Building Code: 2018 NORTH CAROLINA RESIDENTIAL CODE

RESIDENCE FOR:  
**McARTH Y II & PEPPER**  
 53 RELAXING PLACE  
 SERENITY - 50'

Job Number: <b>STY5-0031-00</b>	Drawing Date: <b>05/19/2023</b>	Coord Name: <b>GREG P.</b>	Coord Phone: <b>859-578-4355</b>
House Name: <b>the EPIPHANY II</b>		Drawing Scale: 1/8" = 1'0"	
Contract Drawn By: <b>SSP</b>		Series: <b>SERIES_NM</b>	
Born on Date: <b>01/15/2021</b>		CDs Drawn By: <b>SSP</b>	
Plan No.: <b>PLAN_NM</b>

**2.02S**  
 Second Floor Structural Plan  
 Elevation "B"

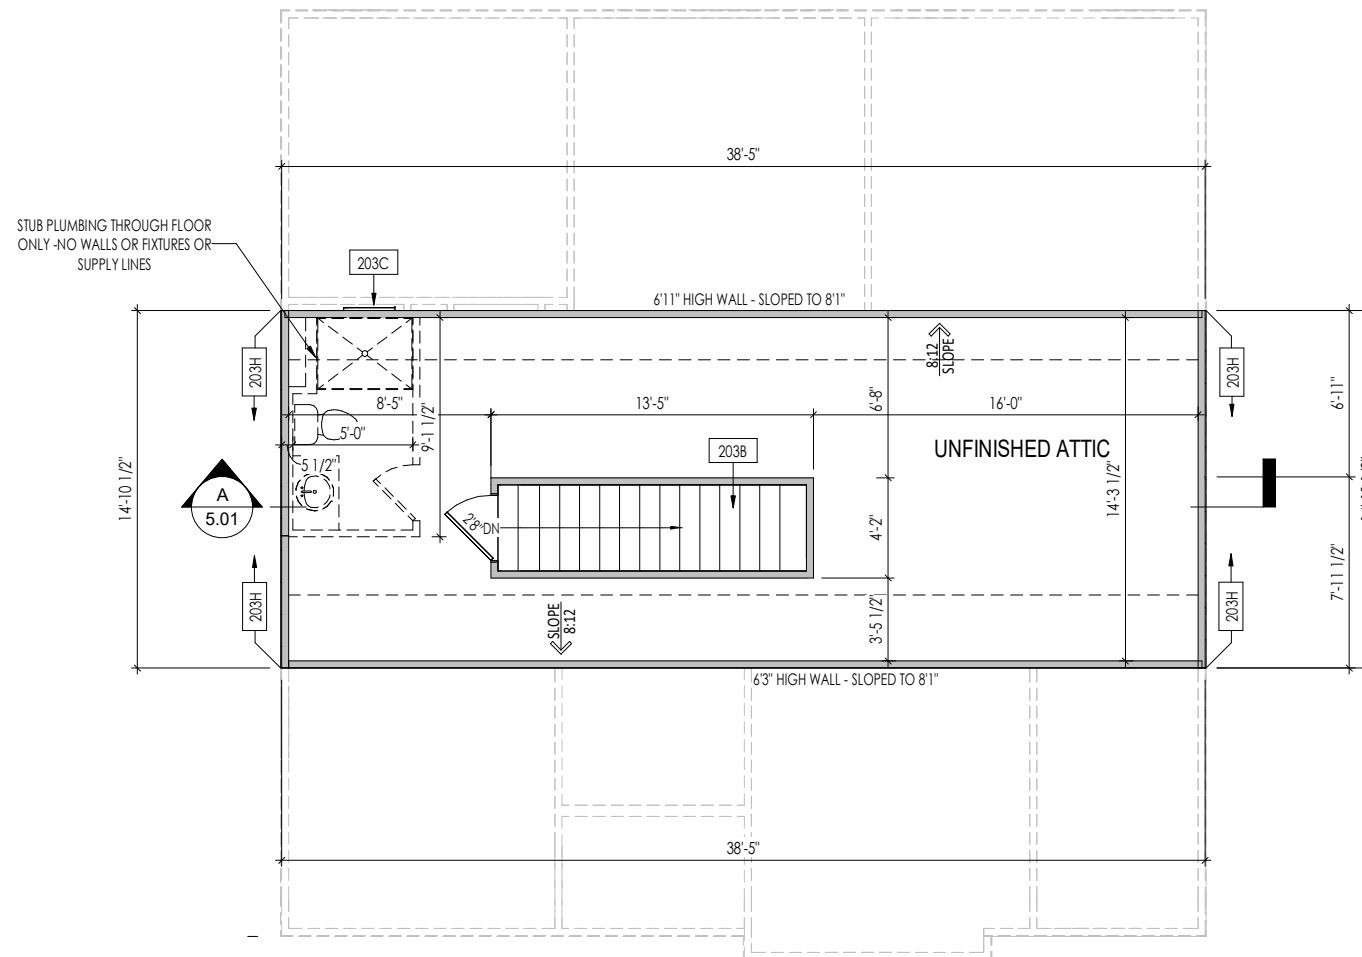
Fire rated egress window required of this is ever finished space
